CITY OF ALBUQUERQUE

July 3, 2018

RE: **Manzano High School Gym
12200 Lomas Blvd NE
Request for Certificate of Occupancy – Temporary
Hydrology Final Inspection - Disapproved
Engineer's Stamp Date 6/8/16 (K22D020)
Certification Dated: 6/22/18**

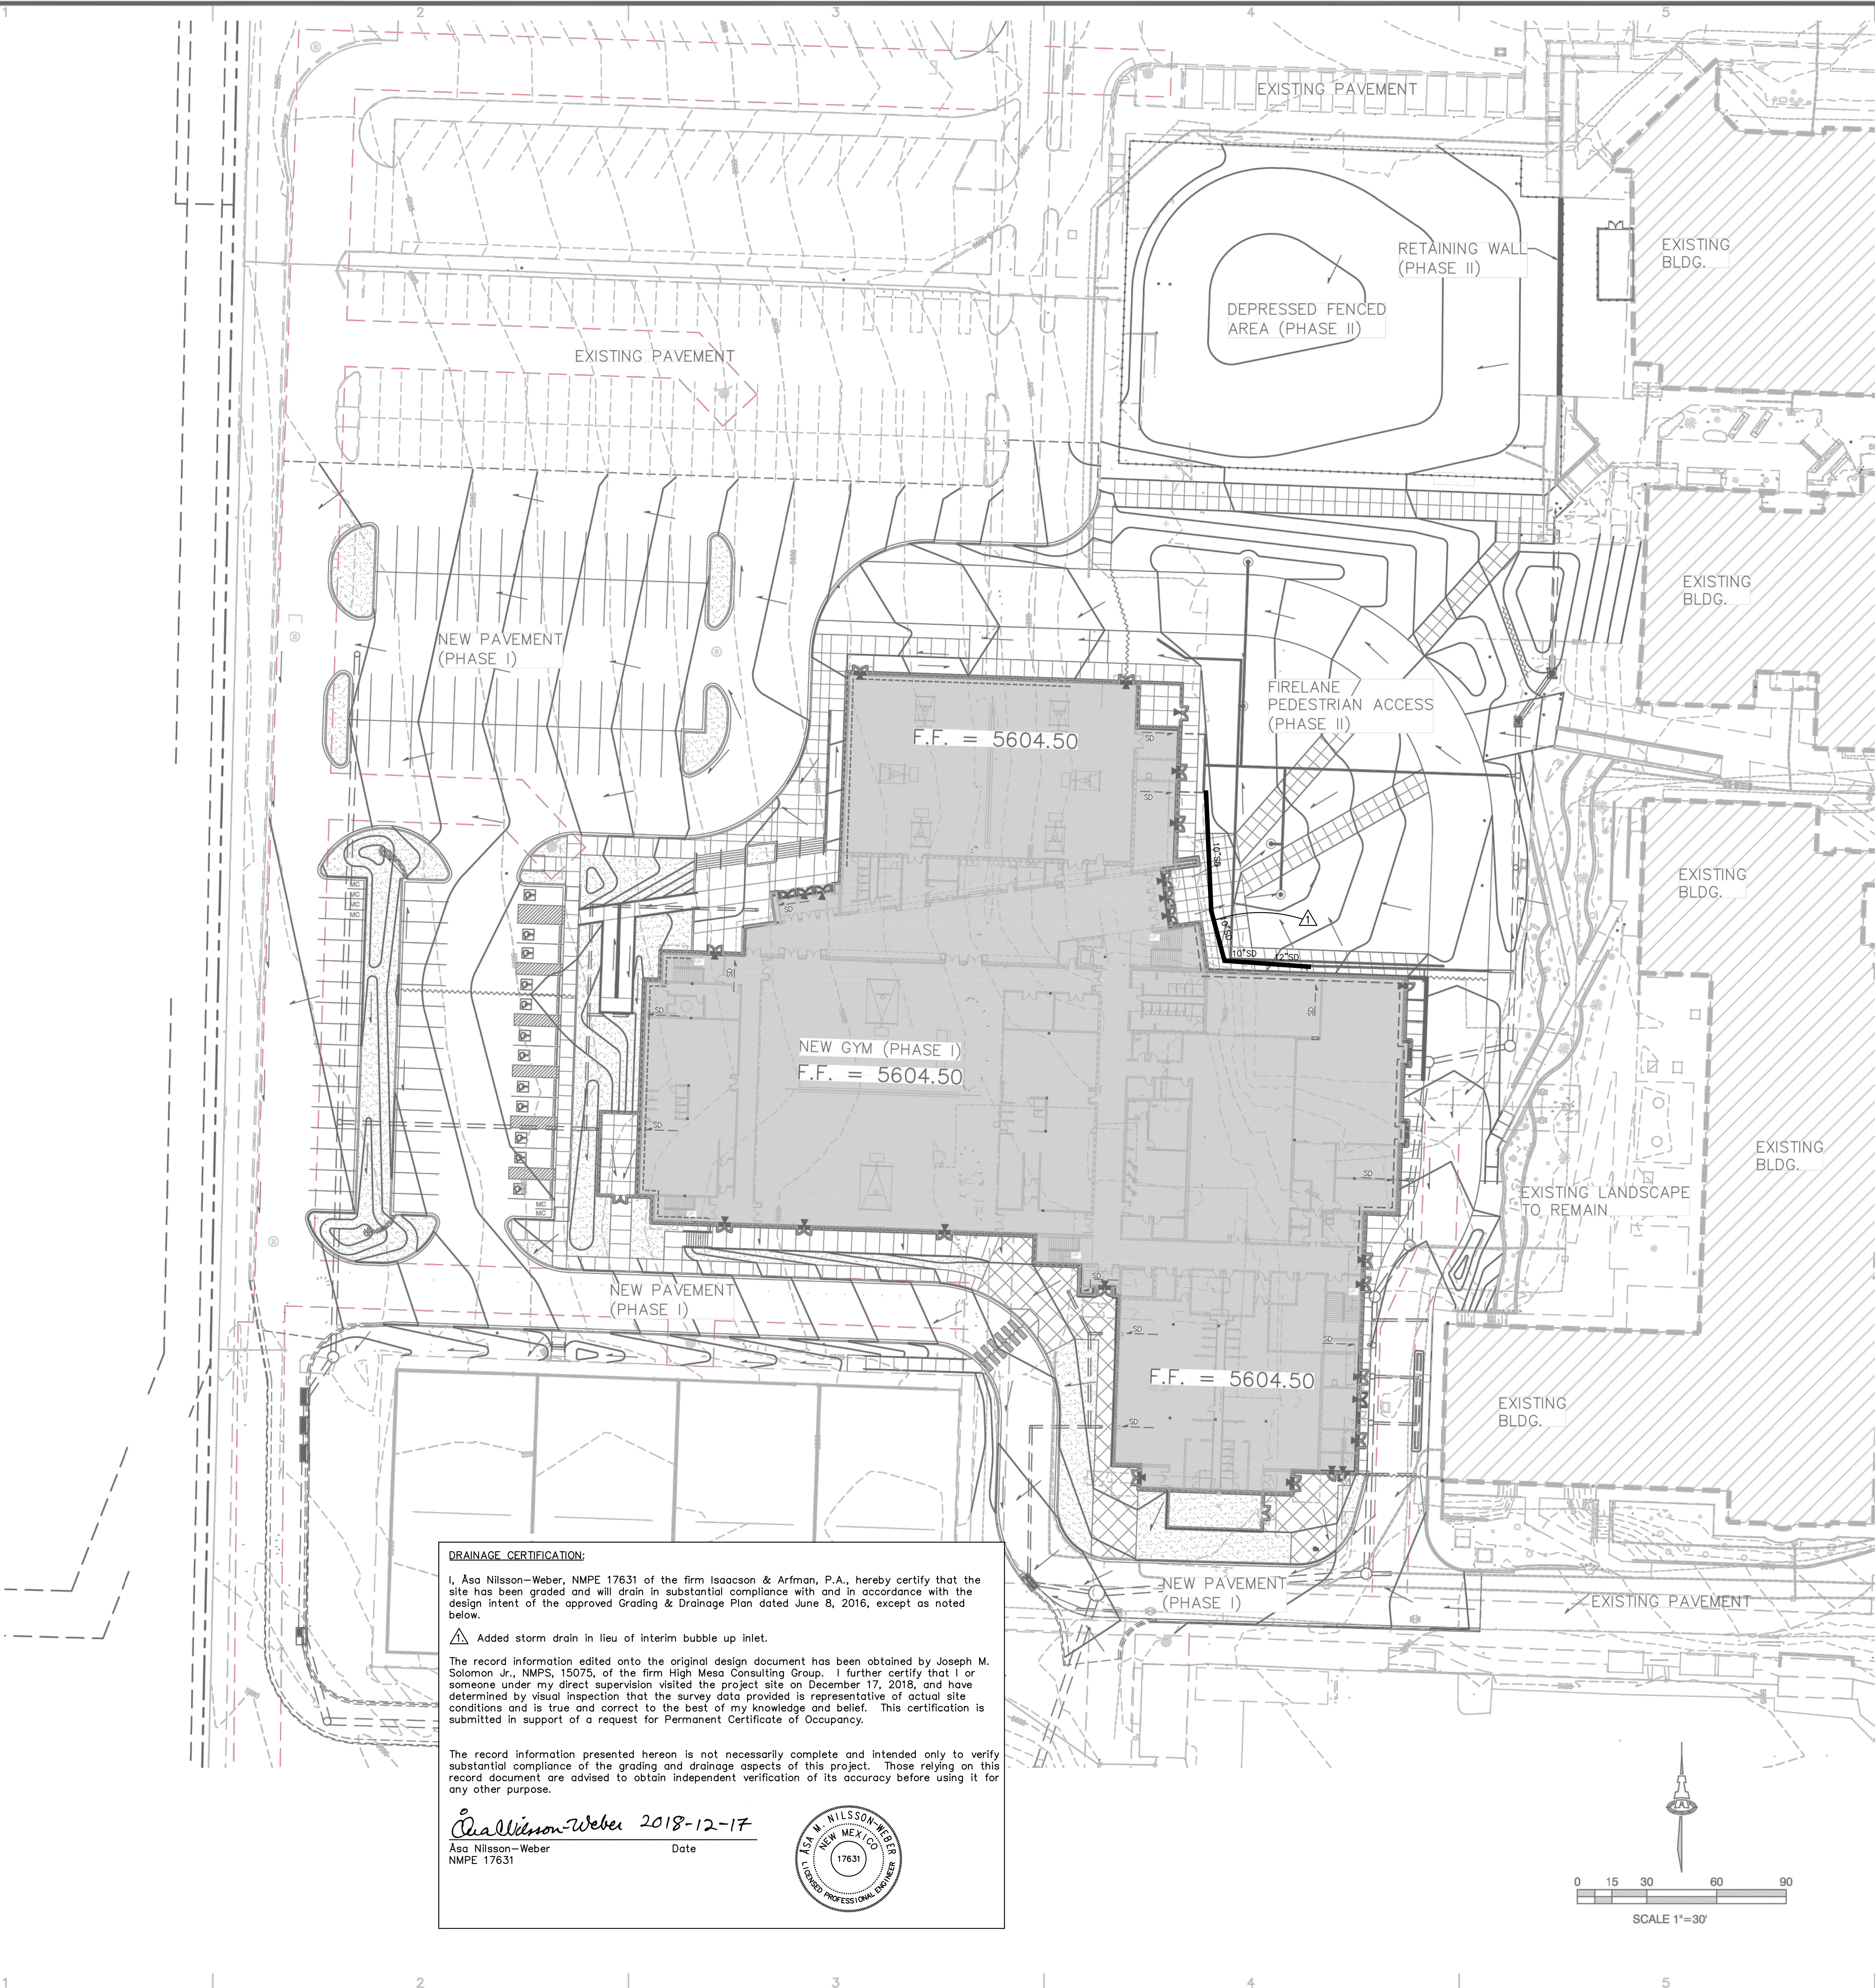
1. The interim grading plan on CG-101 needs to be implemented. The temporary retaining walls, swale, and grading needs to be constructed and surveyed; the removal of the bubblers is acceptable. The area between the new gym and old building needs to be able to drain in the interim condition and be certified as such. Runoff from the old building will pond in the low area along the east side of the new gym. Watermarks are present along the new gym building and there are indications of ponding already. With larger storm events, it is likely that the new building will flood. Photos of the area of concern:

CG-100

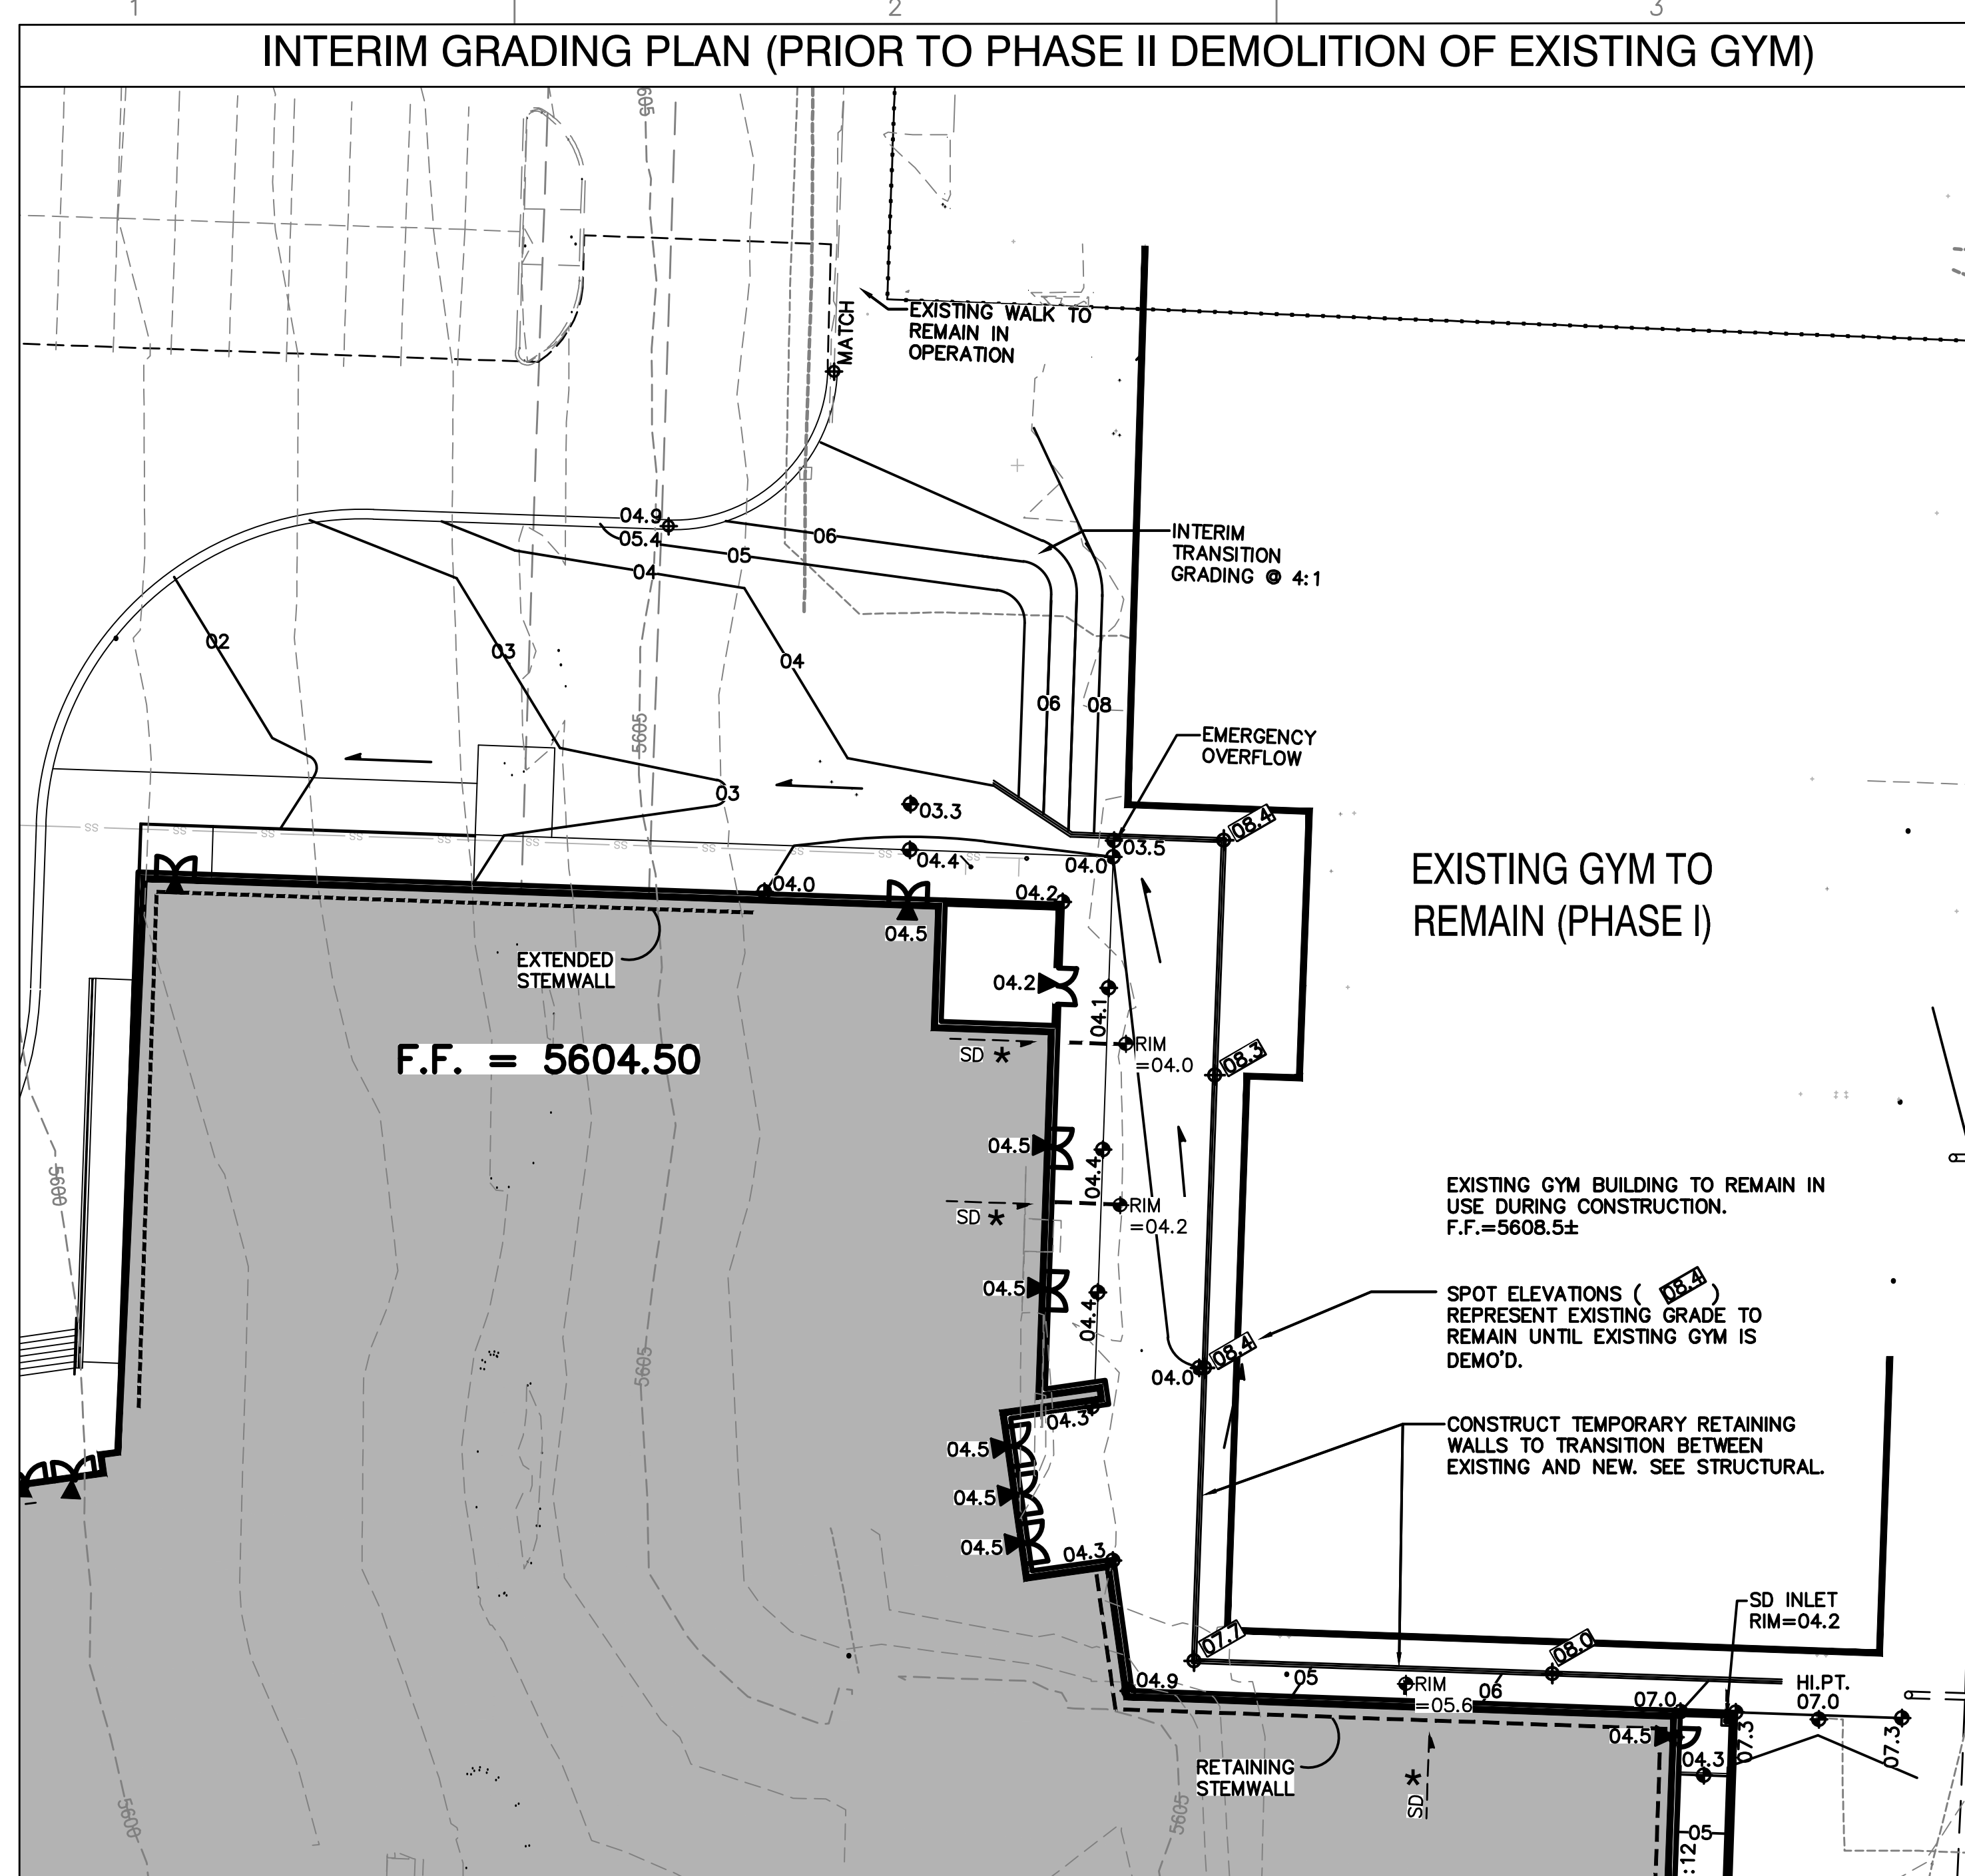
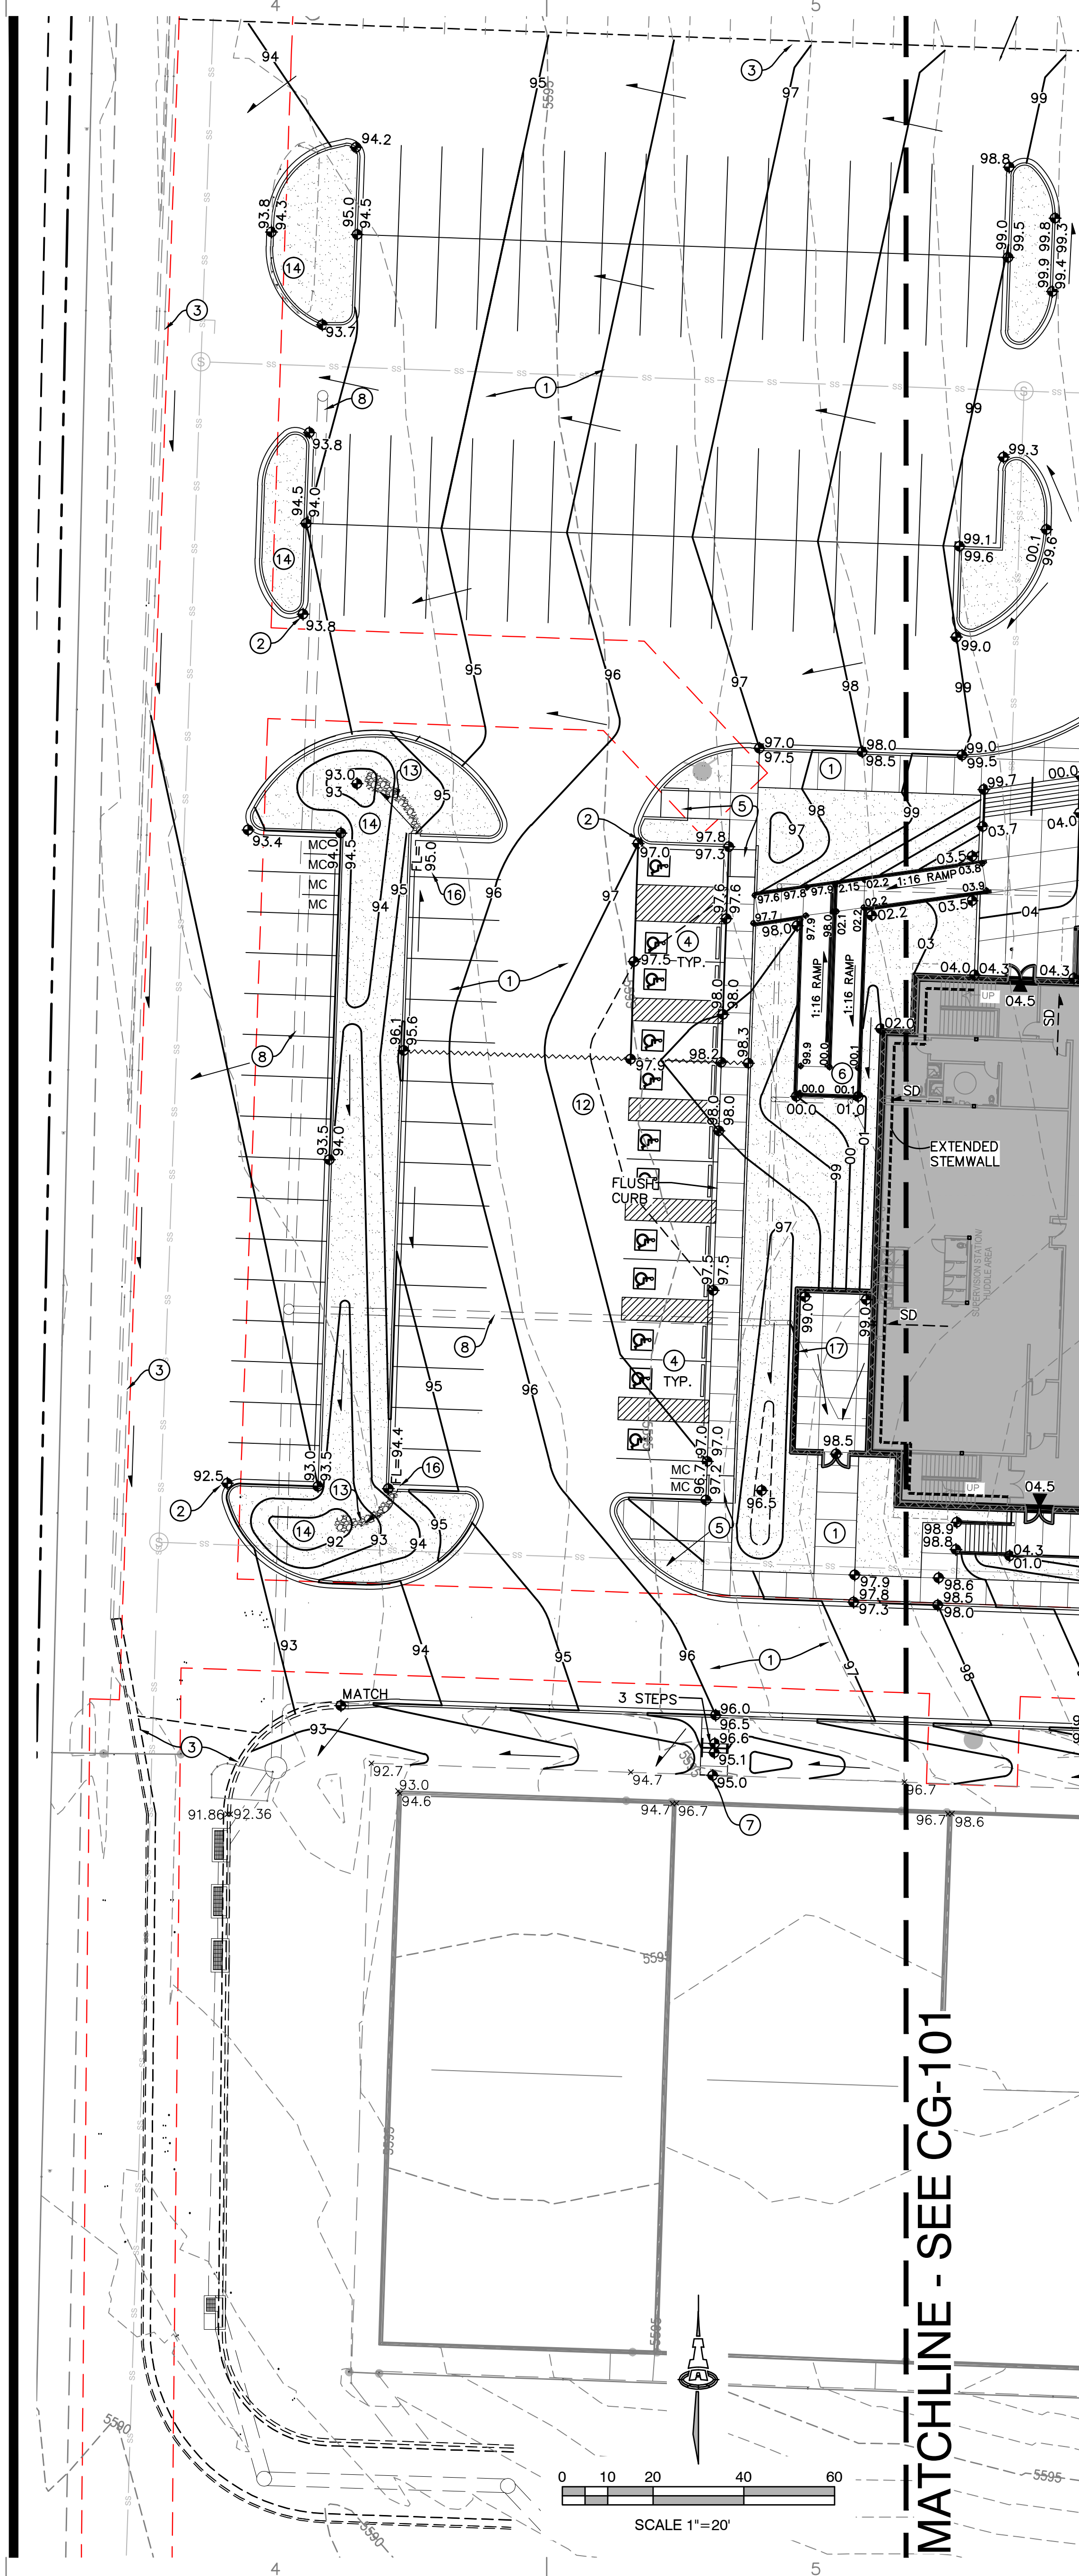
5. The pond in the parking island on the west side of the building needs to be constructed per plan.
6. The full grading and drainage plan will need to be certified (CG-100, CG-101, CG-102, and CG-103).
